KITTITAS COUNTY DEPARTMENT OF PUBLIC WORKS

MEMORANDUM

TO: Lindsey Ozbolt, CDS
FROM: Christina Wollman, Planner III *cw*
DATE: May 2, 2014
SUBJECT: Butler RZ-14-00001

Kittitas County Public Works has reviewed the application for a rezone on the Butler Property on Airport Road.

BUTLER STORAGE  
SITE PLAN  
SR970 CLE ELUM, WASHINGTON

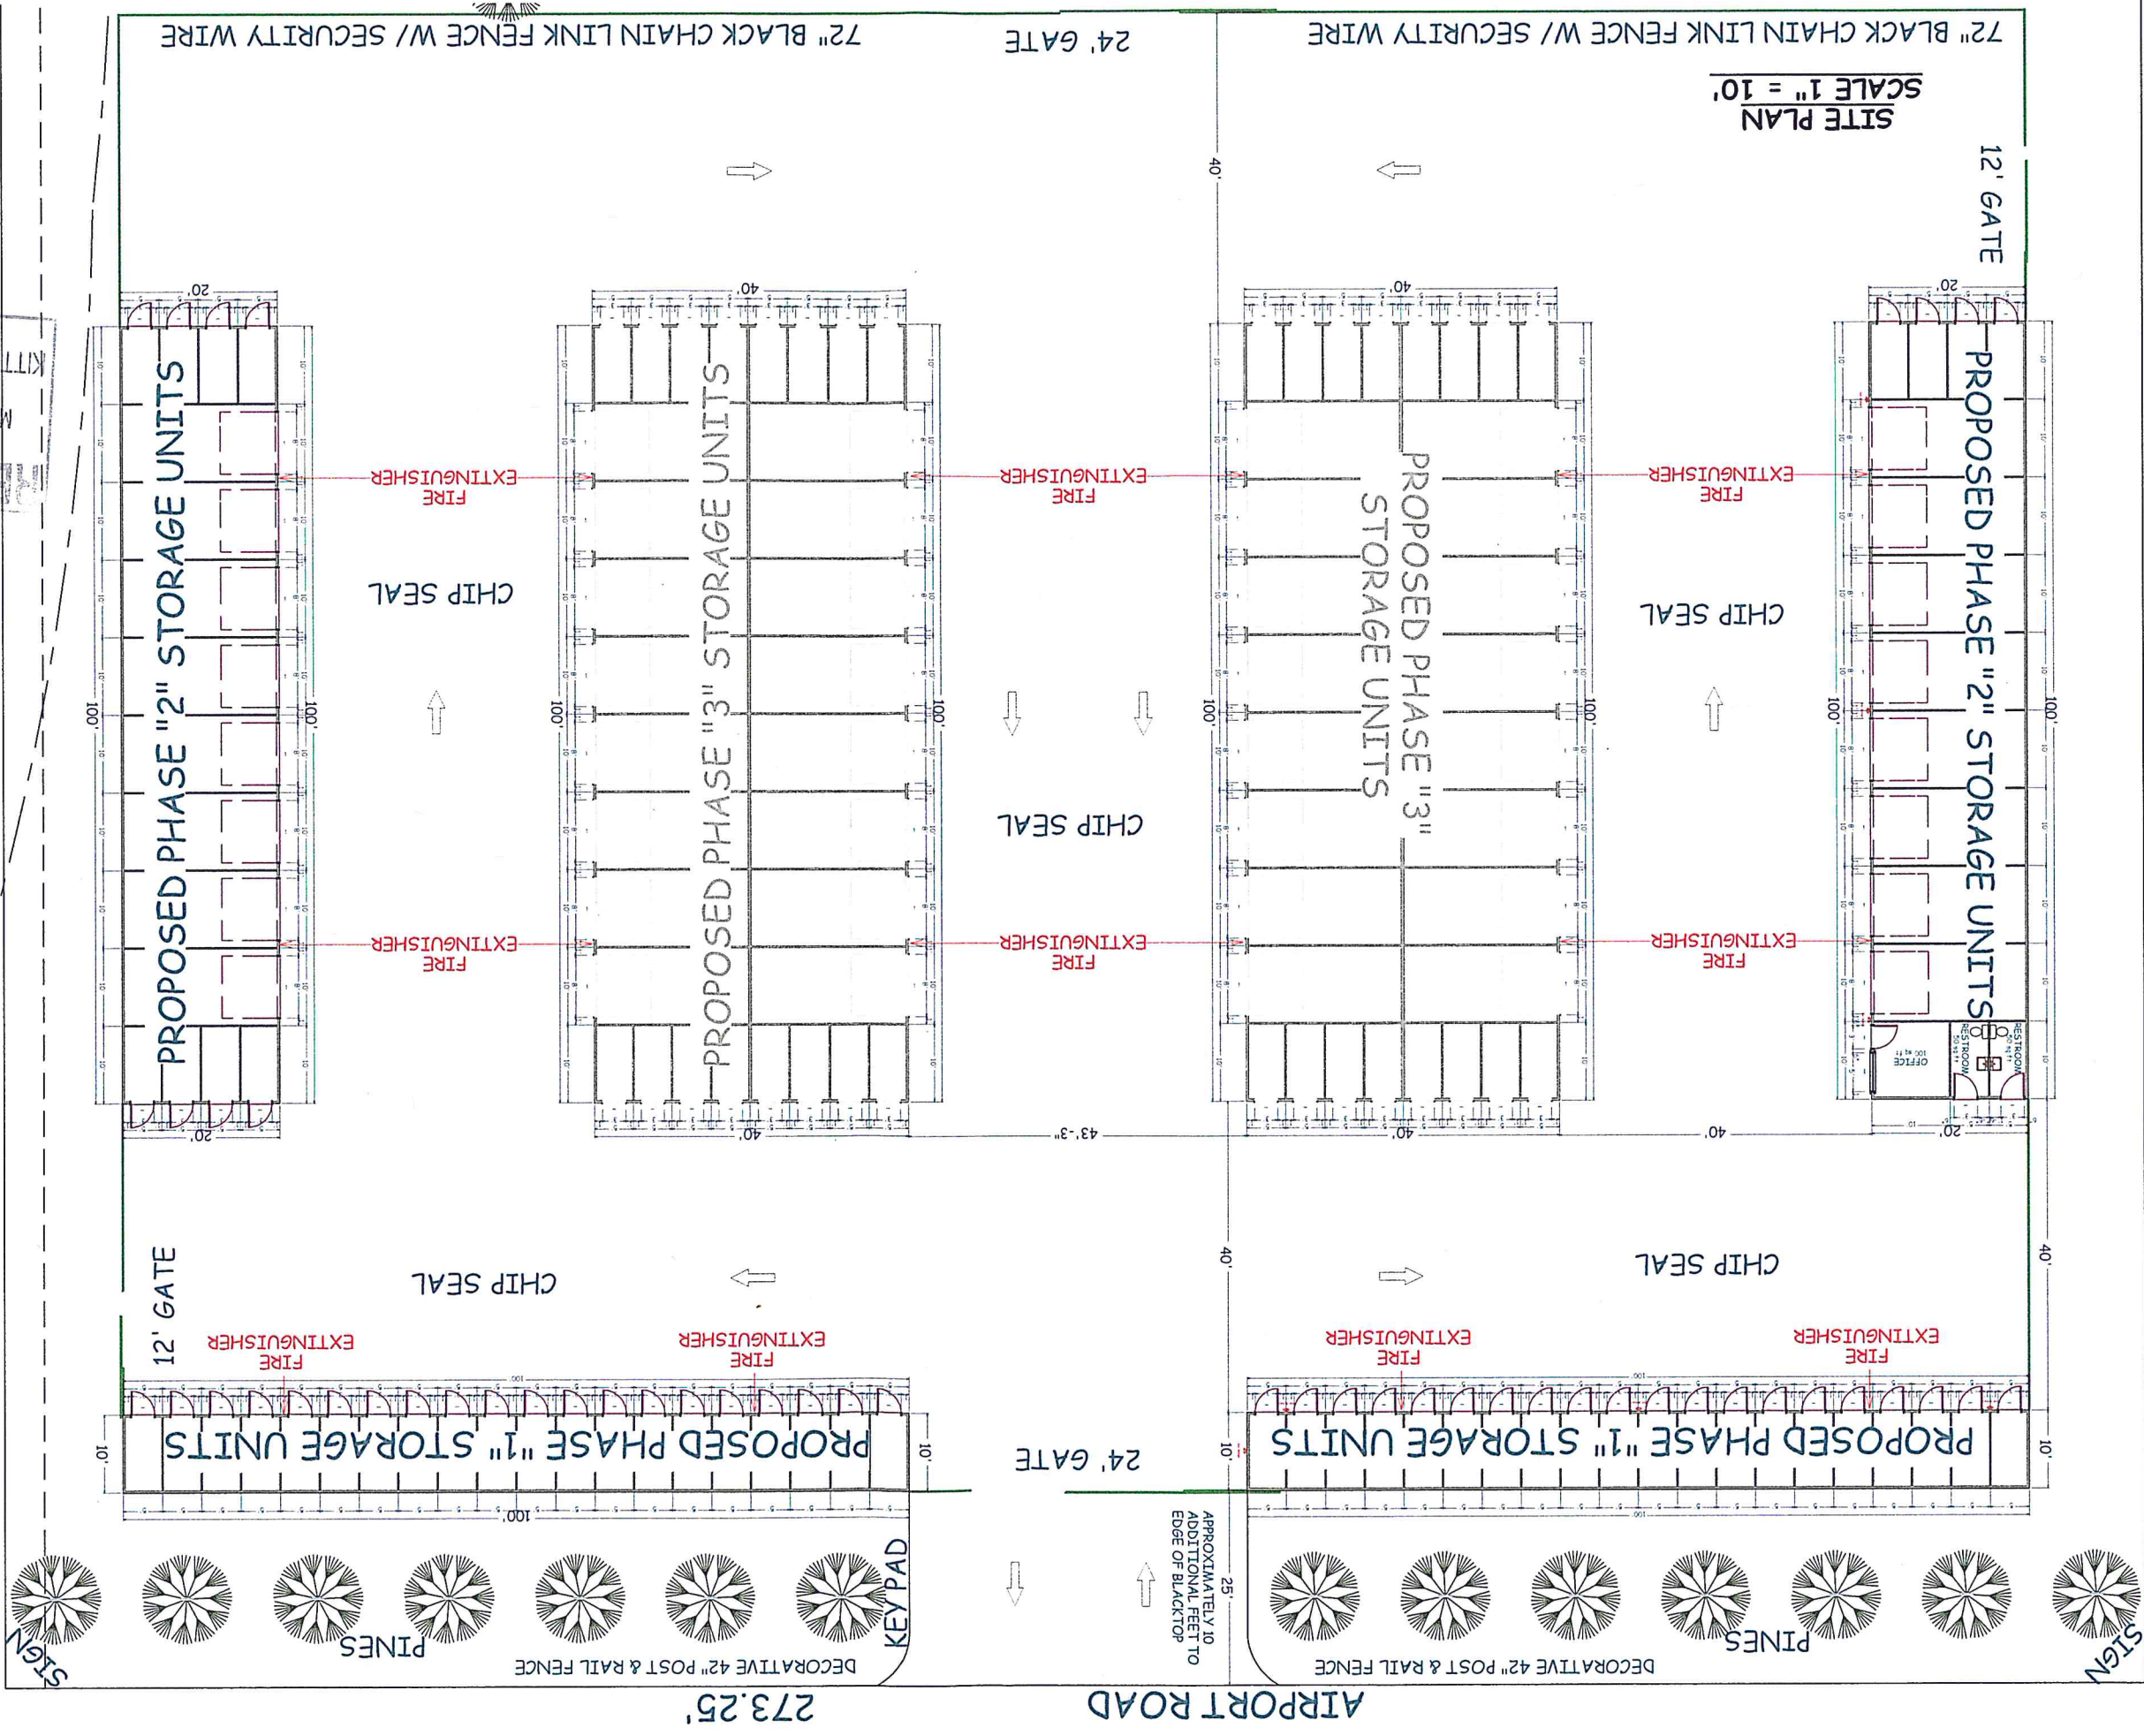
1. **Access:** This project proposes to change the use of the existing access from the county road. The access must be improved to meet commercial standards. An access permit must be applied for and issued prior to beginning any work within the county right of way. Access must be completed prior to issuance of an occupancy permit or final approval.

2. **Stormwater:** On-site stormwater management that conforms to the specifications of the most current version of the Stormwater Management Manual for Eastern Washington is required of this development. Stormwater systems shall be designed to store stormwater generated by a 24-hour, 25-year storm event. Stormwater system designs shall be prepared and stamped by a civil engineer licensed in the State of Washington. The stormwater system design shall be presented to Public Works and reviewed by the County Engineer prior to issuance of a building permit. The stormwater system construction shall be certified by a licensed engineer prior to issuance of an occupancy permit.
